# CITY OF PORTLAND BUILDING PERMIT

Job ID: 2012-09-4977-ALTR

has permission to 12' x 20' shed

## Conditions of Approval:

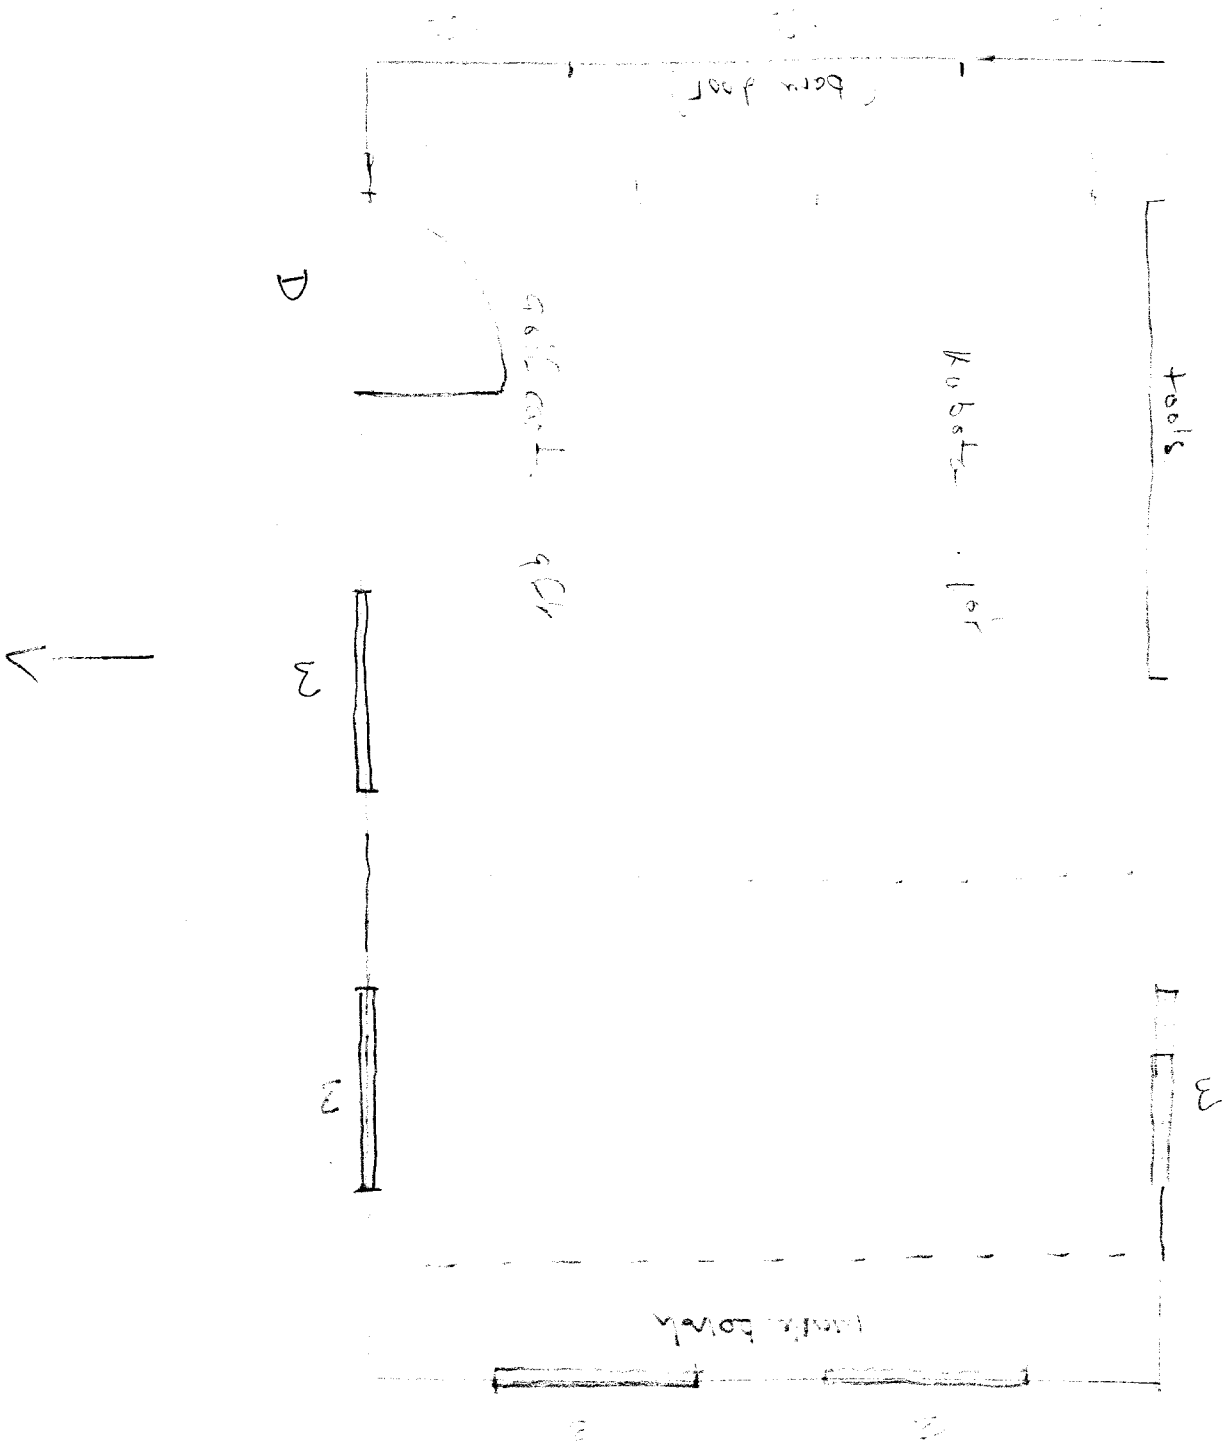
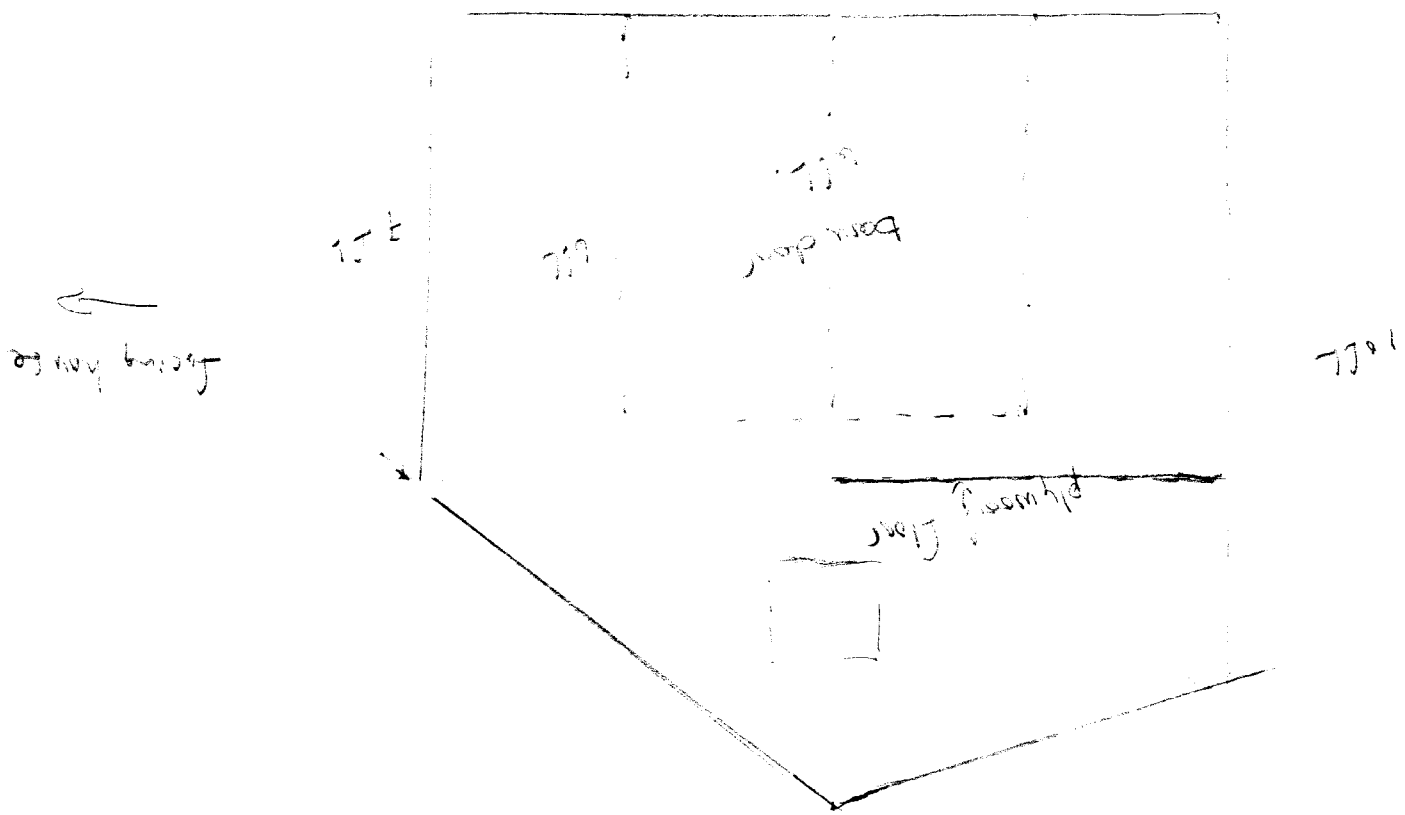
The carrying beam must be 2- 2" x 10"-s minimum.
